**RE: APS Montgomery Complex
3315 Louisiana Blvd NE
Drainage Report and Grading Plan
Engineer's Stamp Date: 4/19/17
Hydrology File: G18D048**

Based on the information provided in your submittal received 4/20/17, the Drainage Report and Grading Plan are not approved for Grading or Building Permit. The following comments need to be addressed for approval of the above referenced project:

OVERALL GRADING & DRAINAGE PLAN

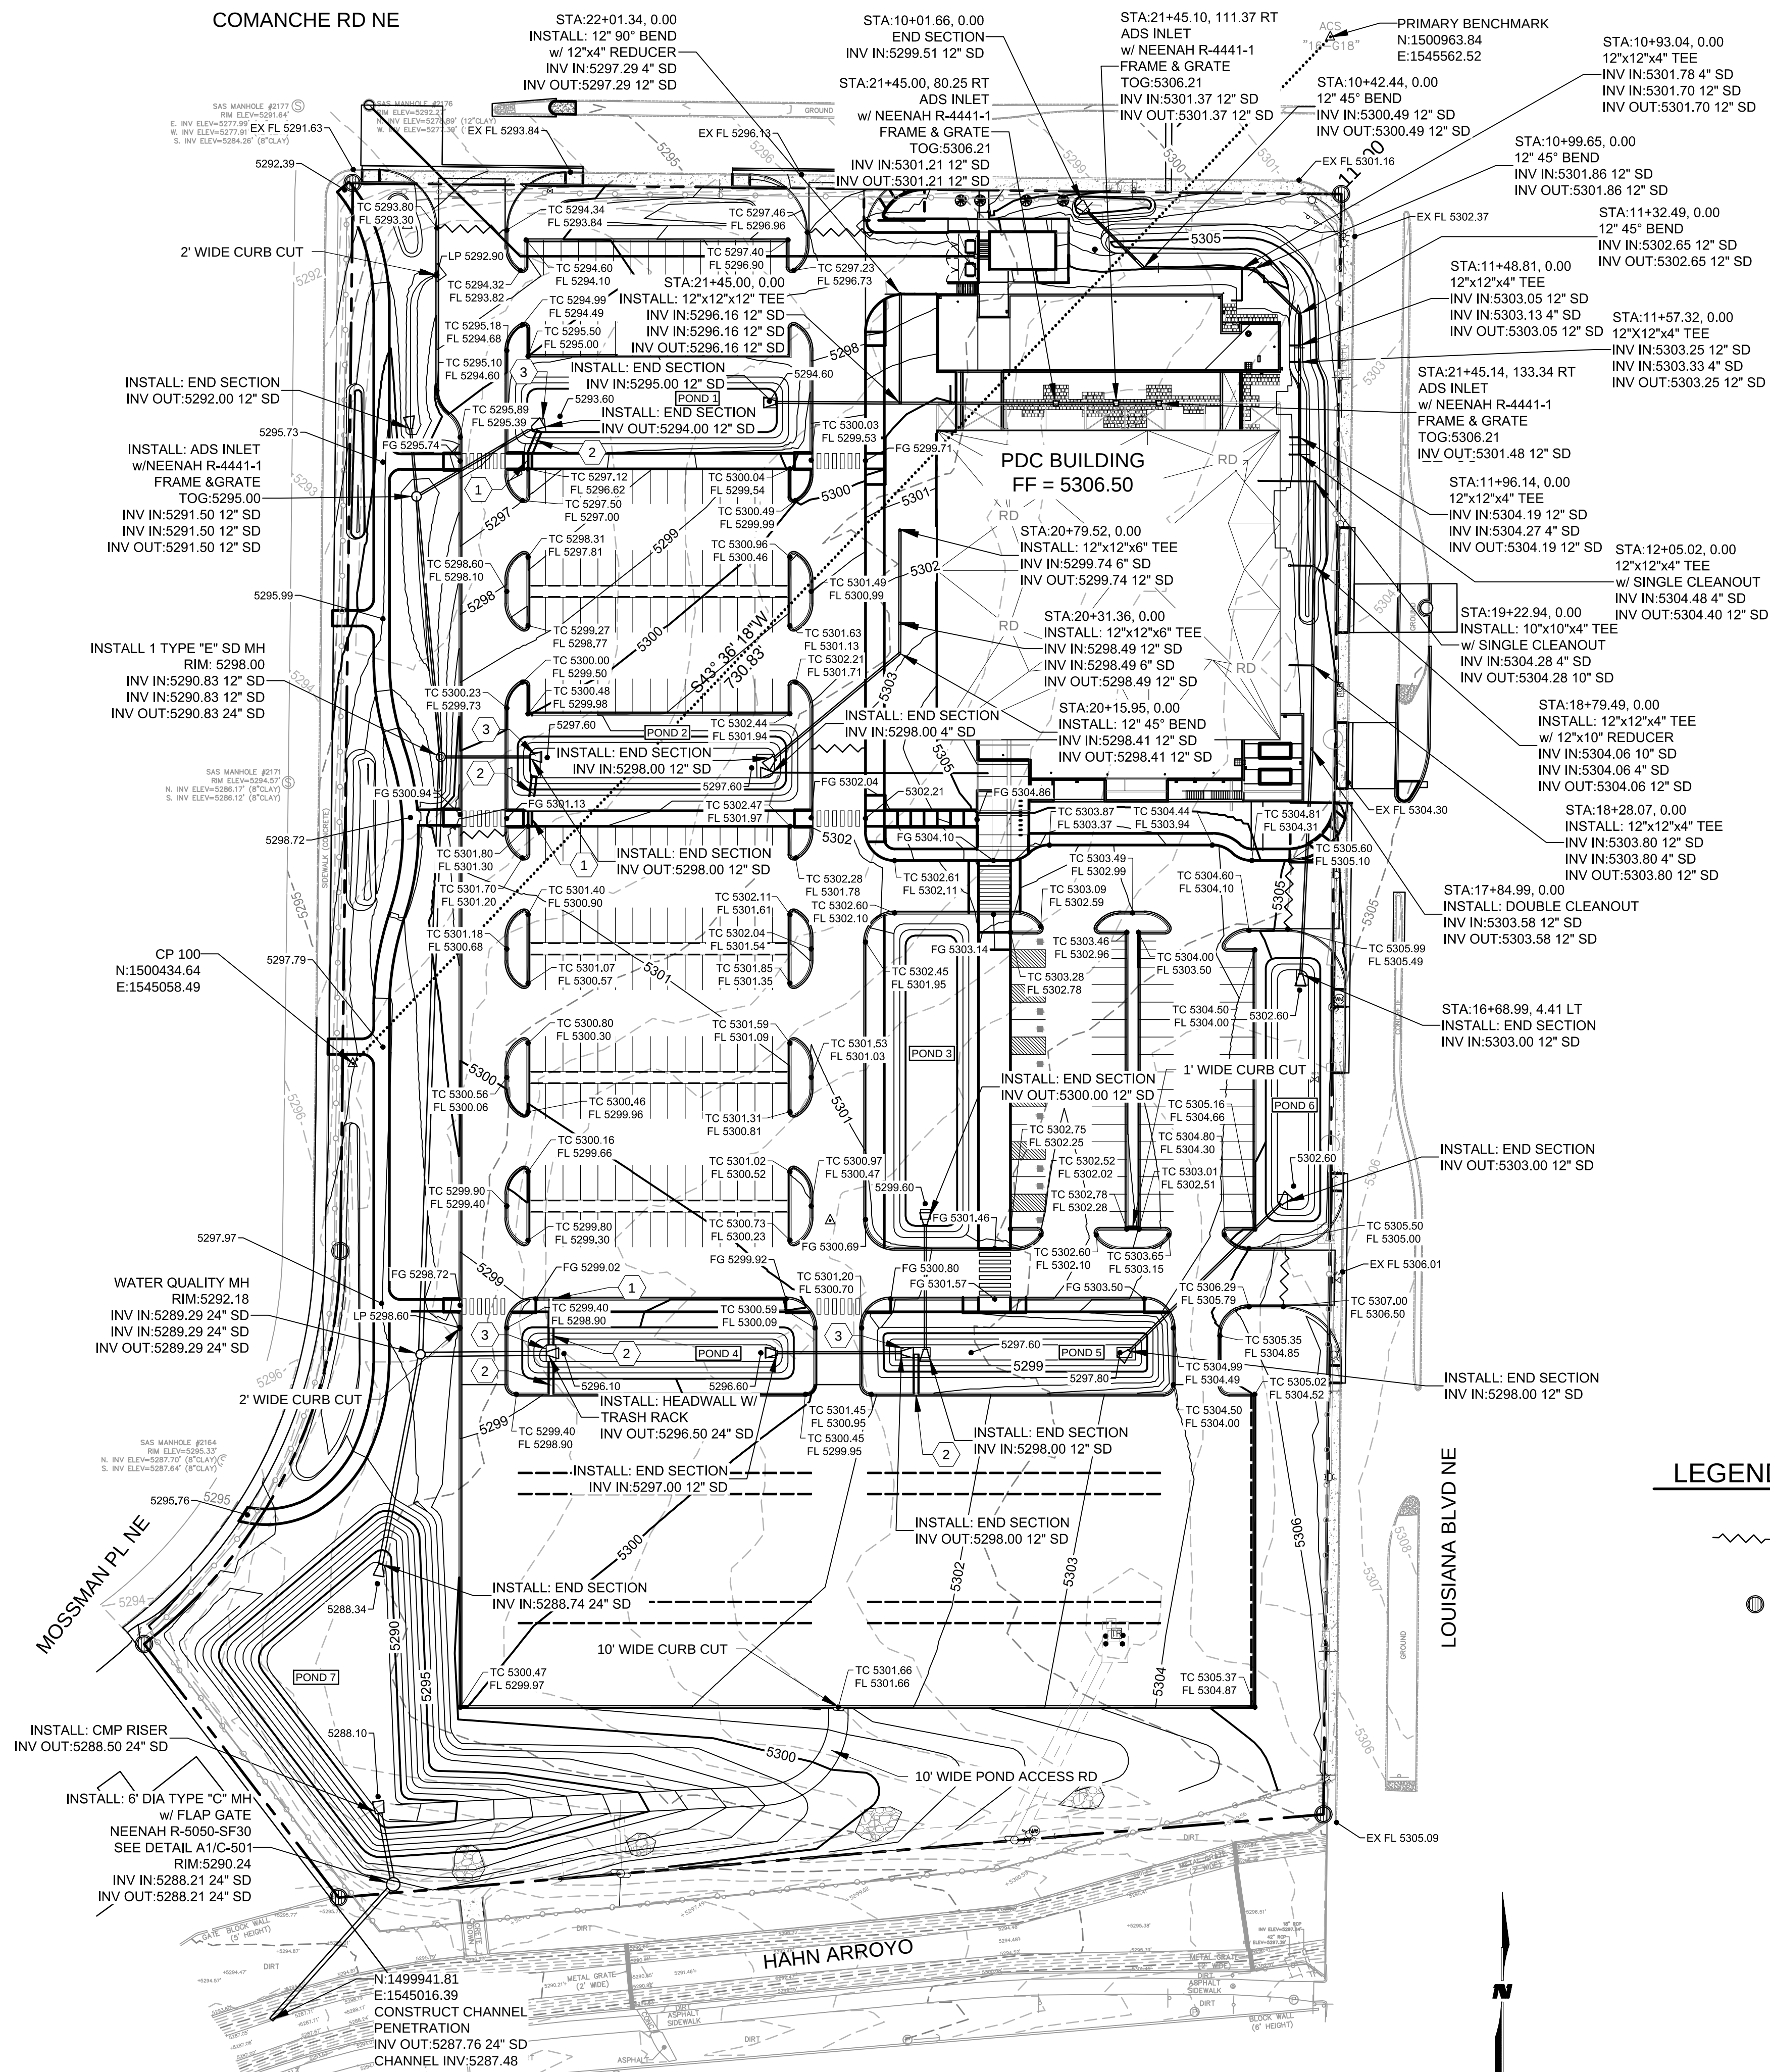
1. Provide finished floor elevation for the PDC building. Assuming the PDC building footprint is outside the Zone AO on Comanche, state so in the report (section 1.3).

2. Pond 7. Provide inlet protection on the outfall to prevent accidental entry. Also include a water quality feature to prevent sediment from washing into South Hahn.

3. Pond 4. Provide inlet protection on the outfall end section to prevent accidental entry.
4. It is unclear how the storm water quality volume is being retained. The report references use of each ponds' dead storage, however the outlet culverts are all within 0.2ft of pond bottom. Provide dead storage volumes and account for allowable error in construction finished grades (likely +/- 0.2 feet).

7. The penetration into South Hahn may be performed under SO-19 or mini- work order. State how the work will be performed on the Grading Plan. If using SO-19, include standard SO-19 notes. Prior to beginning work, notify Jason Rodriguez with Municipal Development to coordinate an inspection schedule (jtrodriguez@cabq.gov).
